30 June 2016

RE: SSD 7047, Darling Harbour Live Interactive Signage Display System

I refer to State Significant Development Application SSD 7047 for signage in the Sydney International Conference, Exhibition and Entertainment Precinct at Darling Harbour.

P1,4

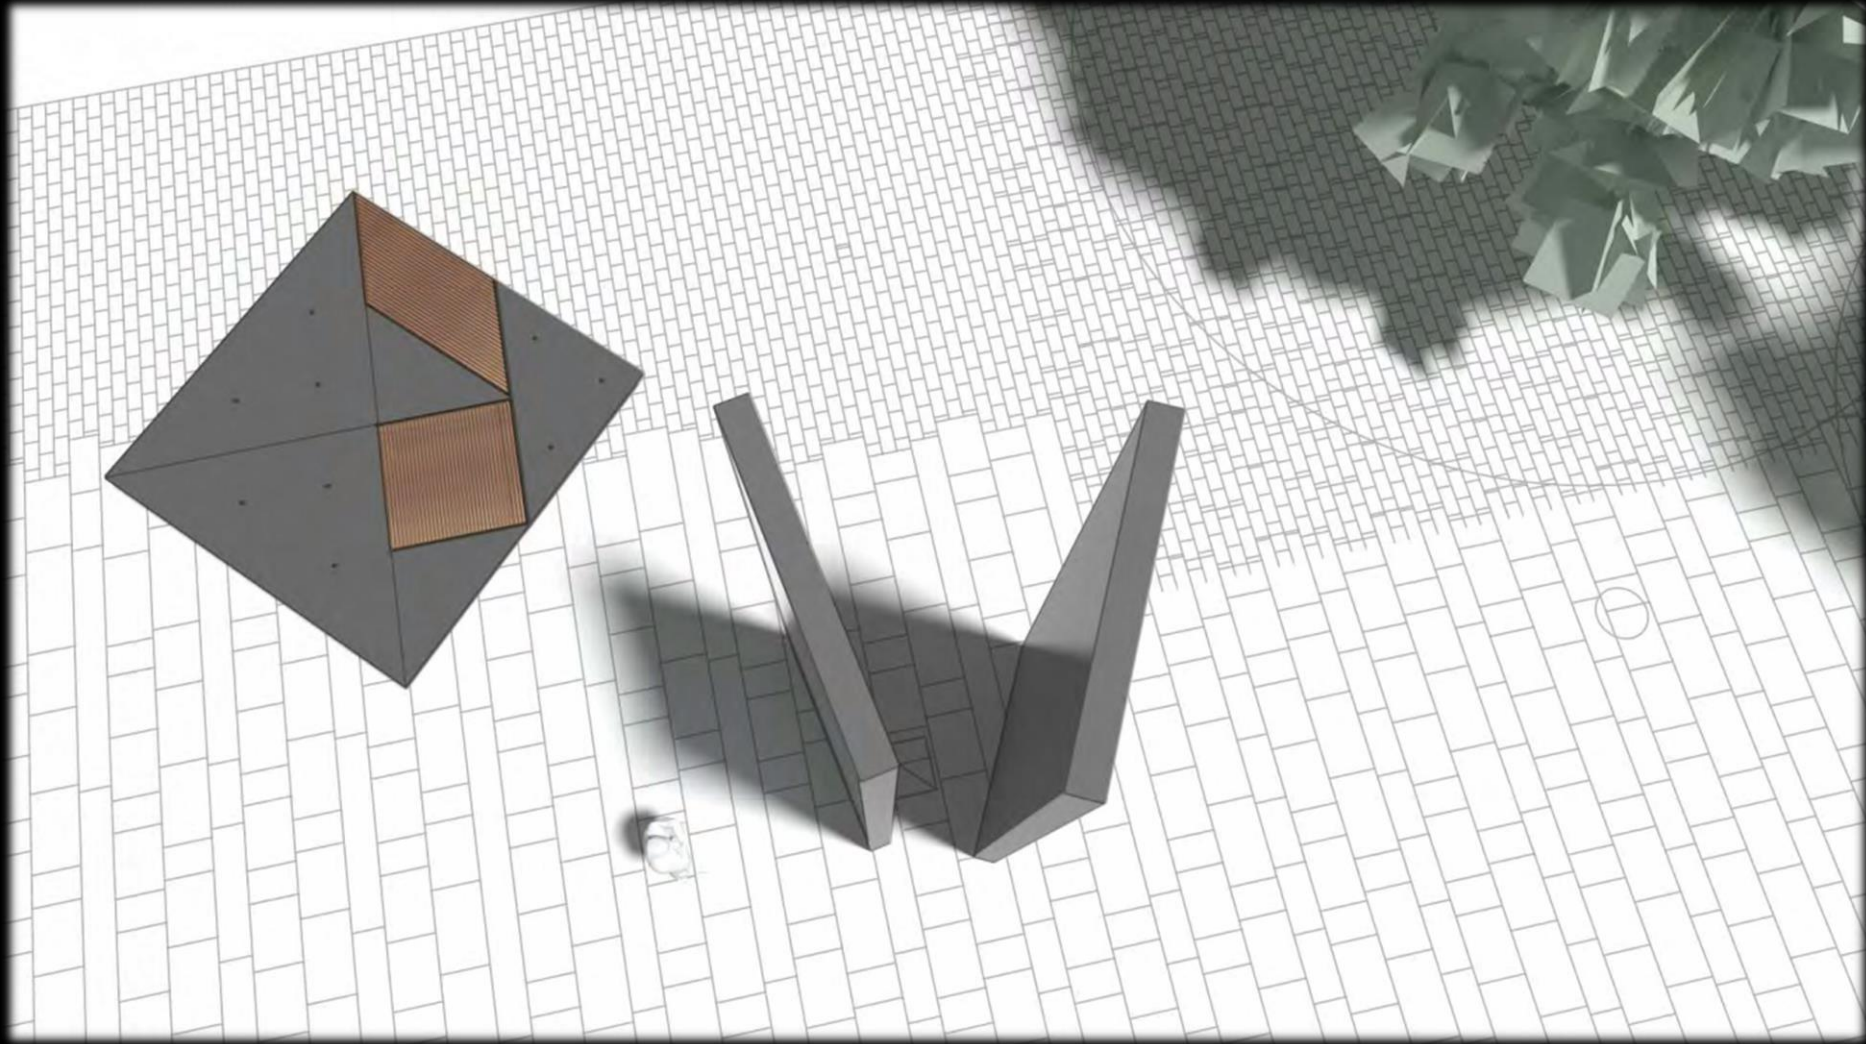
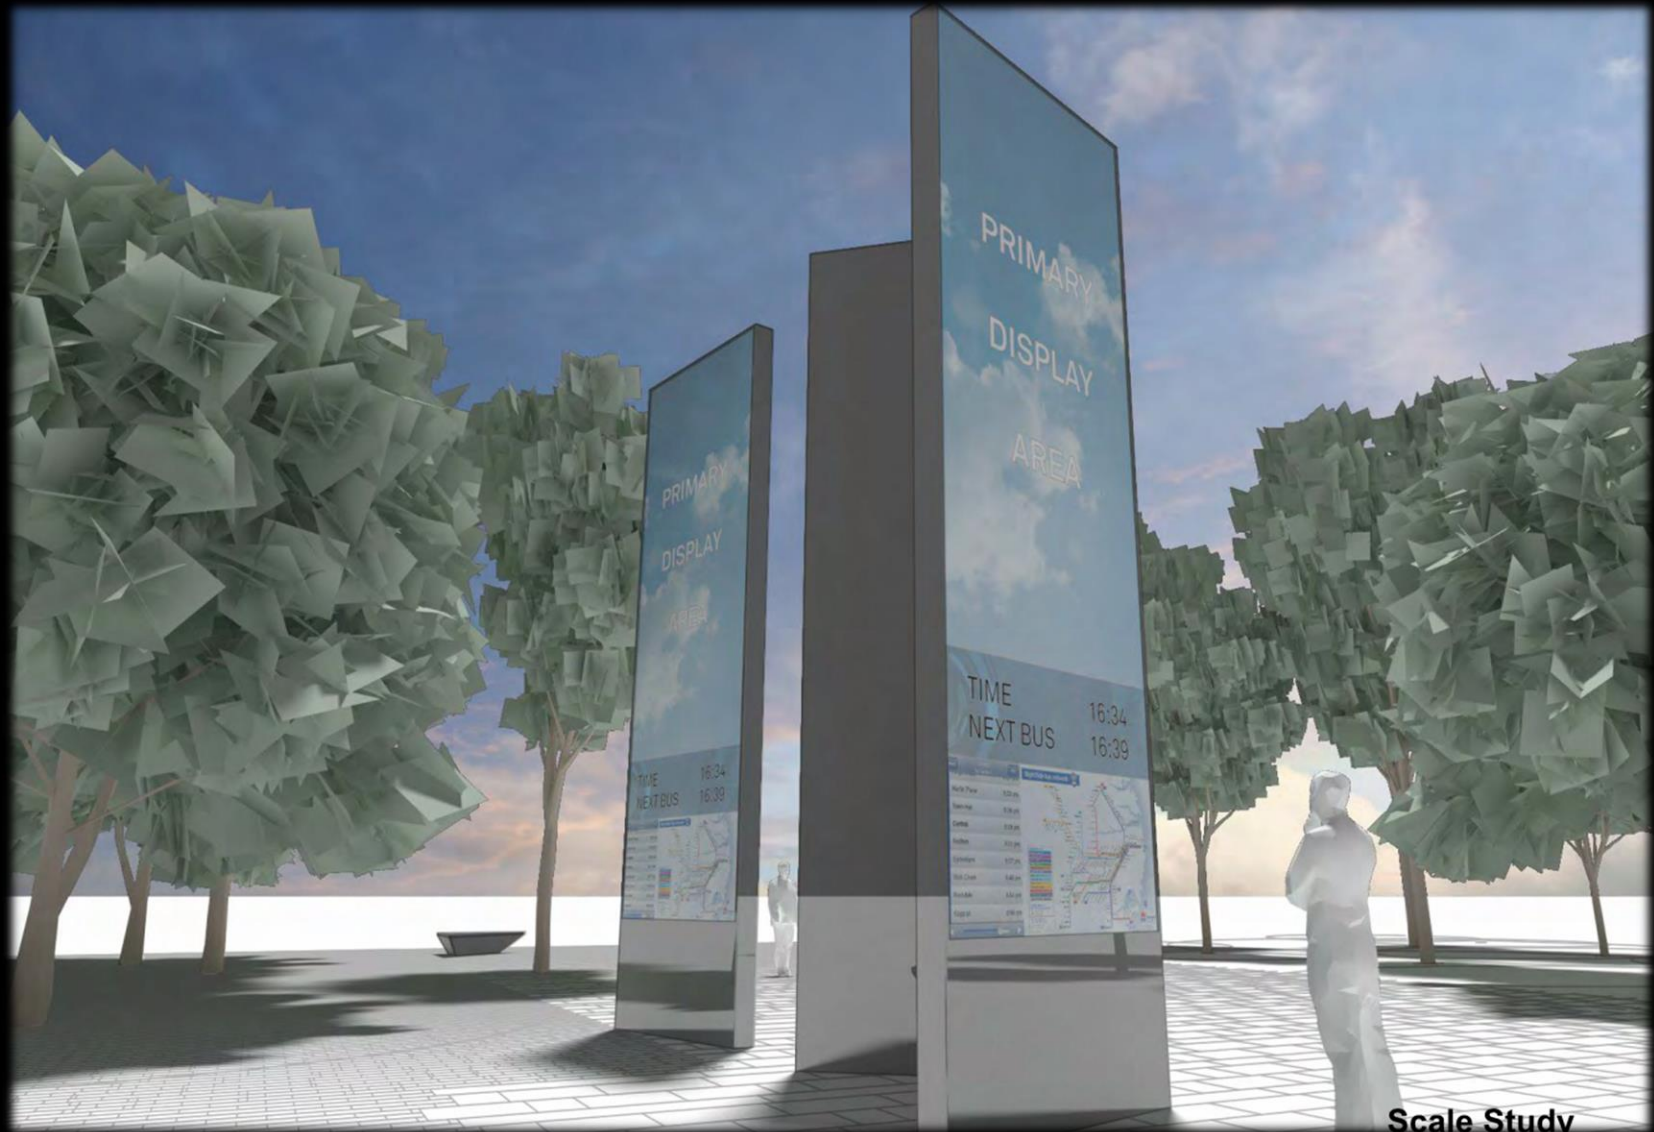
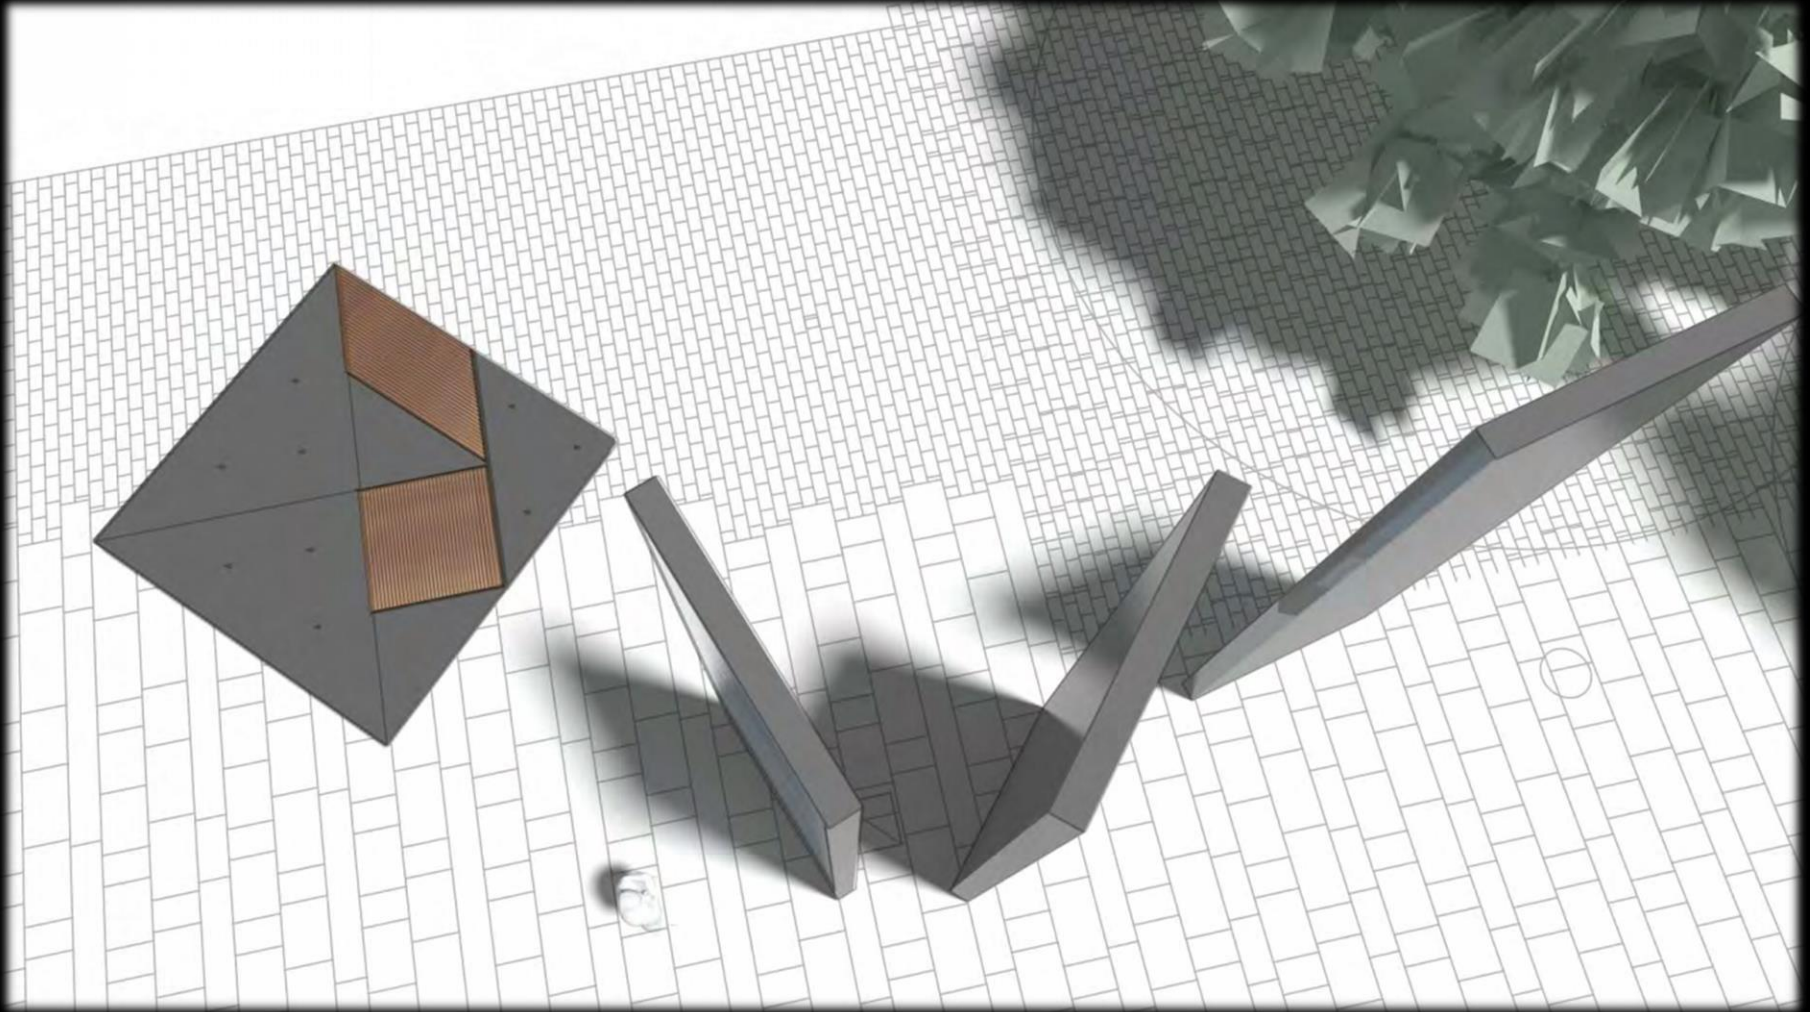
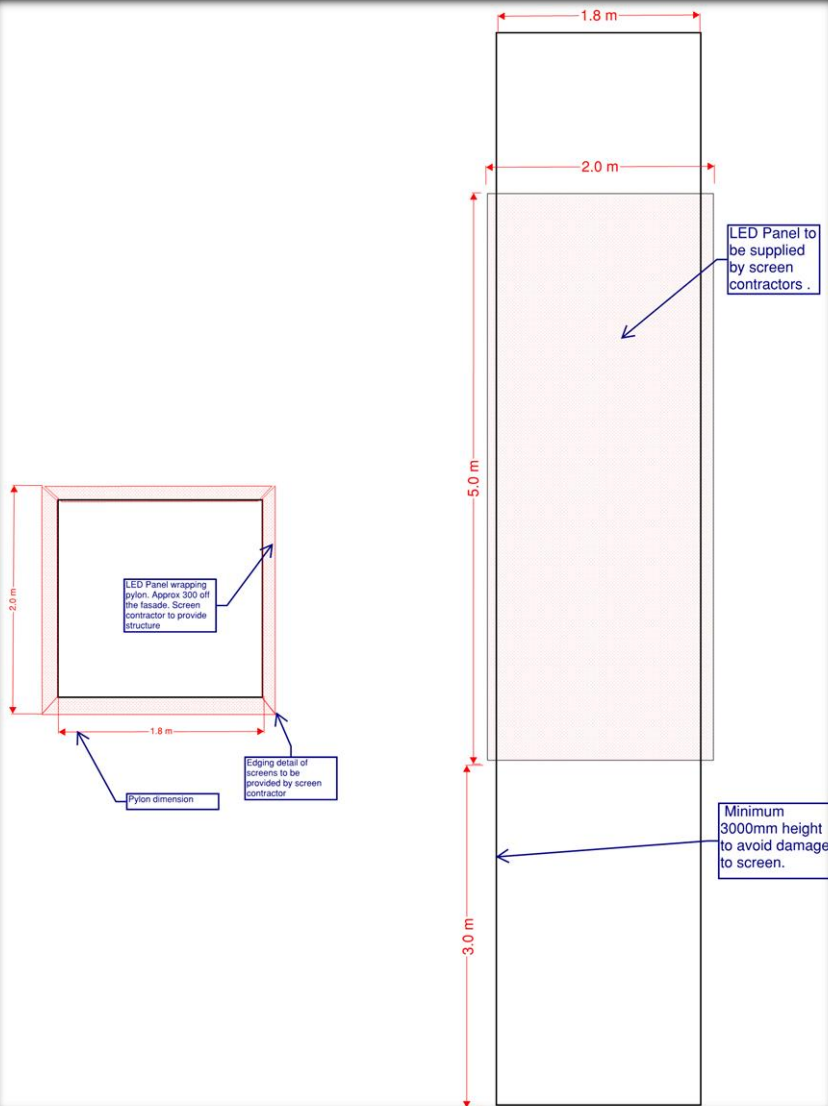
The City has provided photographic evidence to the Department which shows that the proposed signs have been partially constructed. The Consent Authority is unable to grant retrospective approval for works that have already been carried out without consent, and the proposed signs can therefore no longer form part of this proposal.

Notwithstanding this, the City is of the view that the proposed signs:

- are excessive in number (19 in total);
- will result in visual clutter;
- will unnecessarily obstruct the public domain; and
- will include 8m² billboard advertisements for third party advertisers, which are prohibited (refer above).

The City is very concerned given the cumulative advertising area of these signs is 152m². This will undoubtedly result in visual clutter in the precinct and will compromise the amenity and attractiveness of the public space. The signs also face onto a mixed use residential area, yet are proposed to be illuminated 24 hours per day. In light of this, and all of the above, these signs are not supported as currently proposed and it is recommended that they are deleted from the plans.
